From: Simon Davis
Sent: 29 May 2019 10:36
To: Planning.Responses
Subject: FW: AL/27/19/DOC - GTR DENMANS LANE FONTWELL

Further Drainage Consultation Advice

Cc: Simon Davis <Simon.Davis@arun.gov.uk>
Subject: RE: AL/27/19/DOC - GTR DENMANS LANE FONTWELL

Cellular Storage Structure

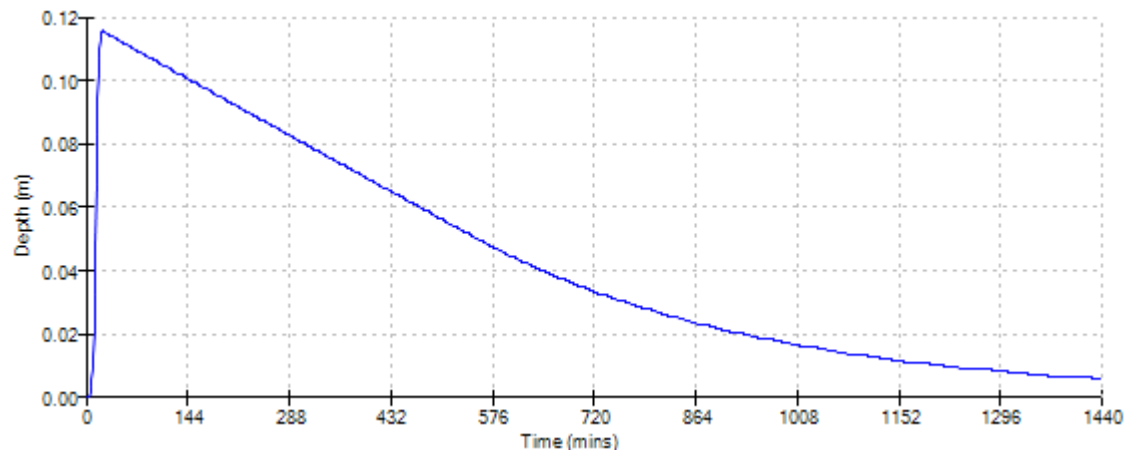
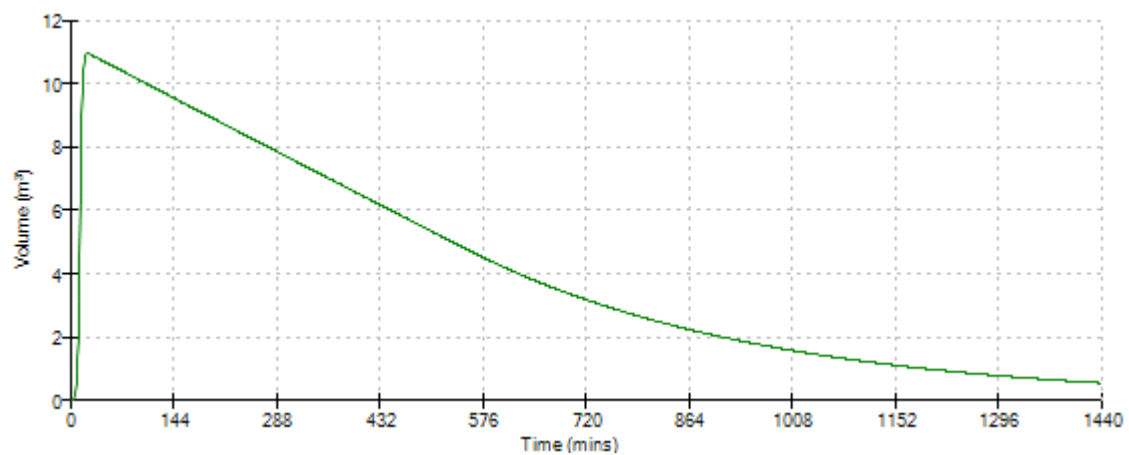
1. Has winter groundwater monitoring been completed? I note there is a statement saying it has, but there are no details as to the duration of testing or the results.
2. Can infiltration test results be provided which show the depth of testing, size of pit, location of pit, and test results for each of the five tests.
3. We require the worst case infiltration test result at the proposed location.
4. We require the actual windes calculations to be submitted.
5. Layout plans and construction detail drawings are required.
